This submission predominately relates to the Bylong Coal (the proponent) Groundwater *Impact Assessment* (the Assessment), prepared by Australian Groundwater and Environmental Consultants Pty Ltd (AGE) (June 2015). This submission is not confidential.

Figure 7.21

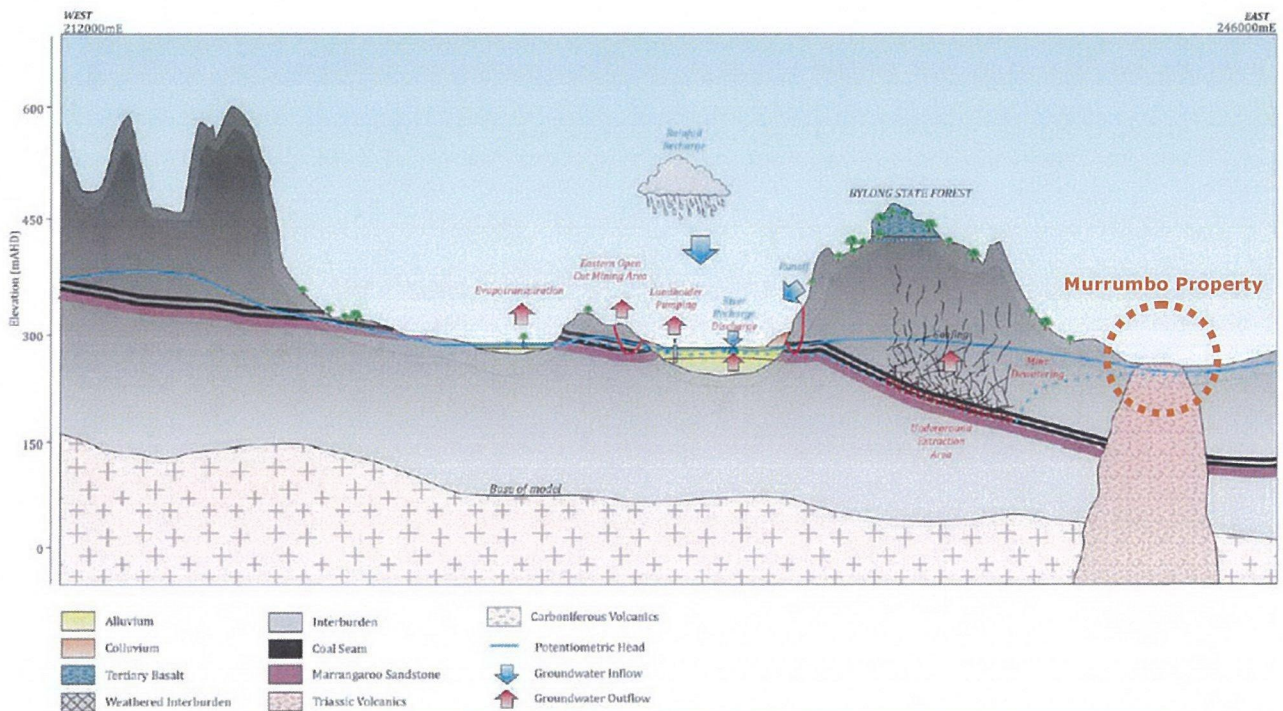
In addition the stratigraphic table, Figure 5.14, is not site specific and is not consistent with the units used in Figure 7.21. The cross section in Figure 7.21 is also not consistent with the surface outcrop shown in Figure 5.16, notably the Triassic units are absent.
